SF2016/095761; WST16/00050/02

**DA 374-11-00 MOD 3: Lots 4-10 and Part Lot 13 DP 754021; Wilmatha Road, Fifield;
Response to Submissions; Syerston Nickel Coal Project – Scandium Oxide Modification**

Roads and Maritime Services

Figure 7: Transport Route

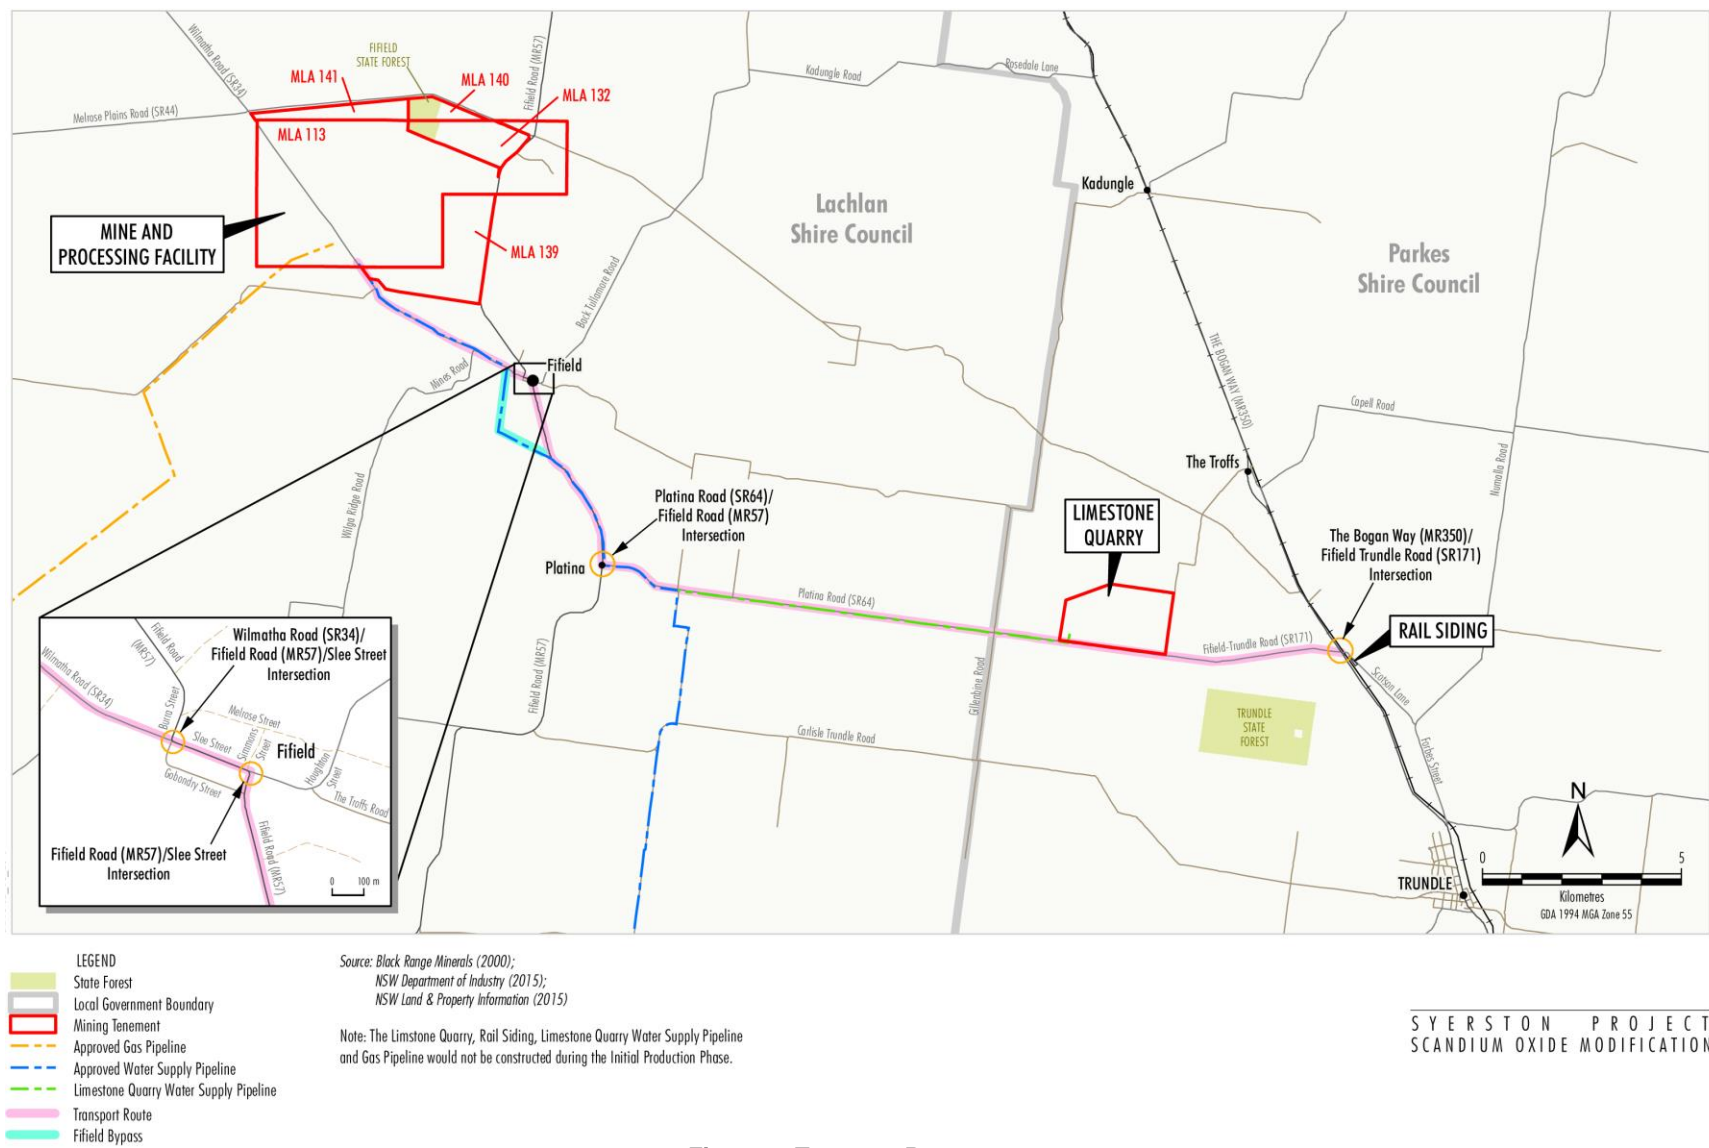
The RtS has been reviewed. I note the applicant generally concurs with the comments made by Roads and Maritime in its submission dated 23 May 2016, with the exception being the timing of the Middle Trundle Road/Henry Parkes Way (MR61) upgrade. Roads and Maritime reiterates that this work needs to be completed prior to the operation of the initial production phase.

As discussed on 16 June 2016, the upgrade of this intersection to include a Basic Right (BAR) turn treatment is required for the initial production phase only. Should the full production phase be realised in the future, as per condition 7.4(d) of DA374-11-00, the intersection will need to be upgraded to include a channelised right turn lane.
